Land North of Yapton Primary School
Planning Ref Y/88/18/OUT
December 19th, 2018

Land North of Yapton Primary School
Planning Ref Y/88/18/OUT

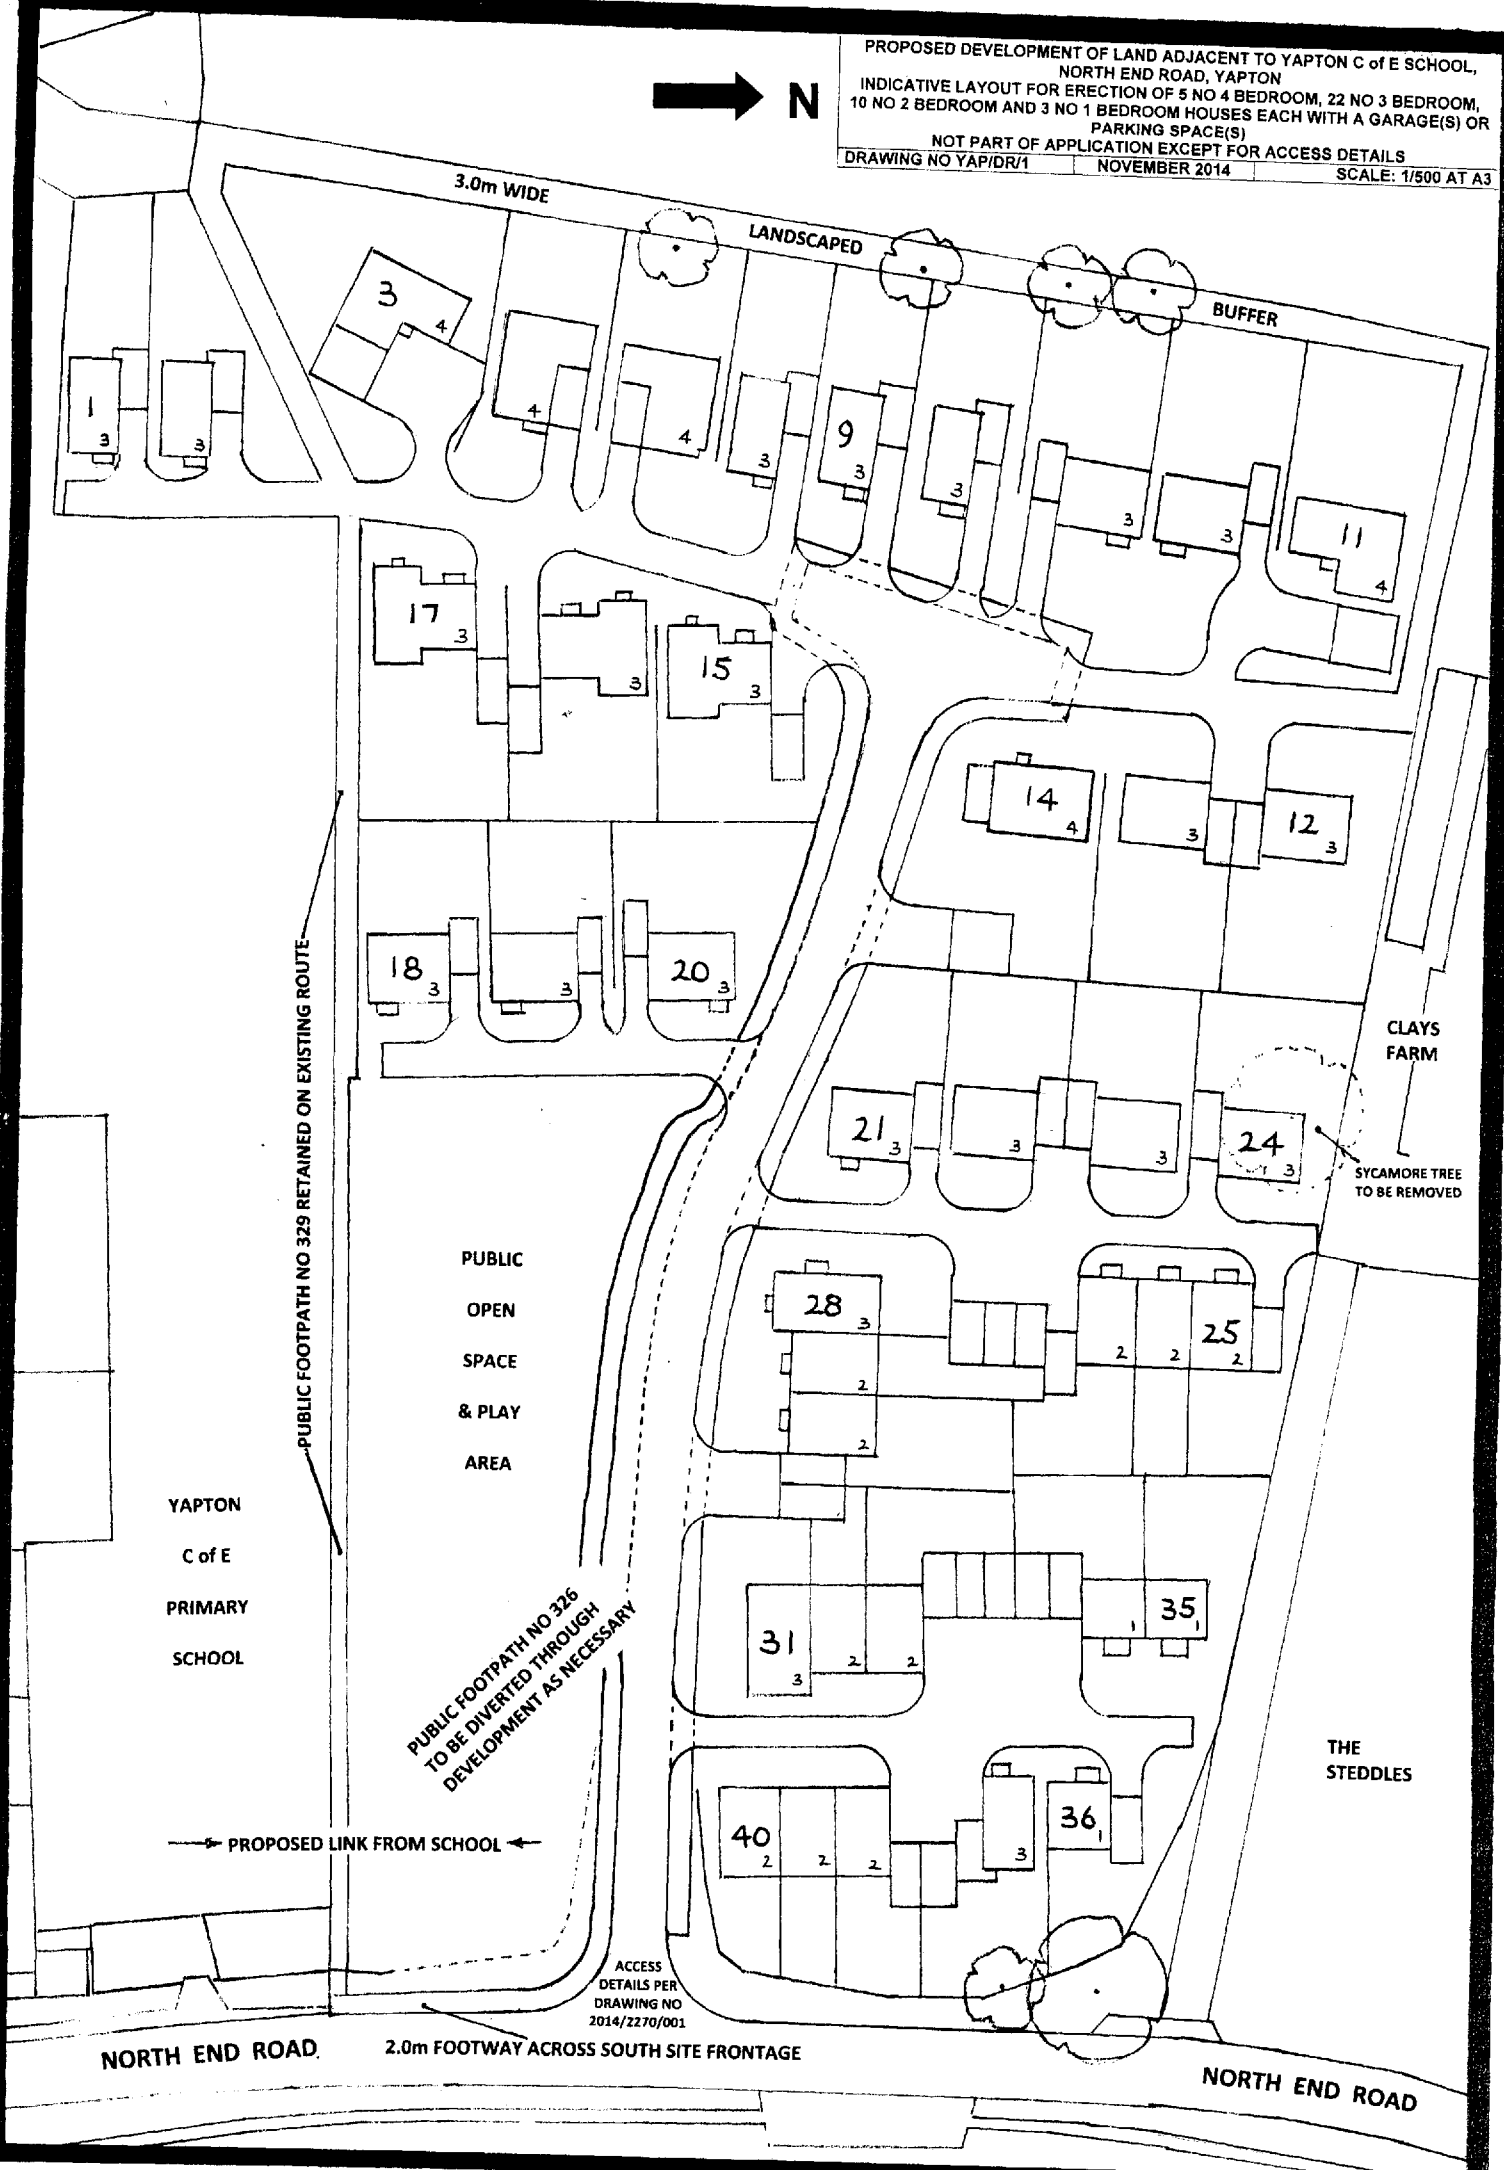
YPC note that a 5m buffer is being proposed along the western boundary and would seek that this is widened to accommodate such a multi-use path that will link with the Staker's Farm and Bonham's schemes (Y/44/17/OUT and Y/1/17/OUT respectively)

With regard to the existing PRow YPC expect it to be reinstated and upgraded to allow multi use ensuring that it a public right of way for the whole community and not simply the fully able. It must be recognised that this PRow is currently a very rural footpath linking open fields to the public. YPC expect the PRow to have improved landscaping to ensure that the PRow maintains the 'illusion' of a rural route and not simply a narrow alleyway running behind new housing.
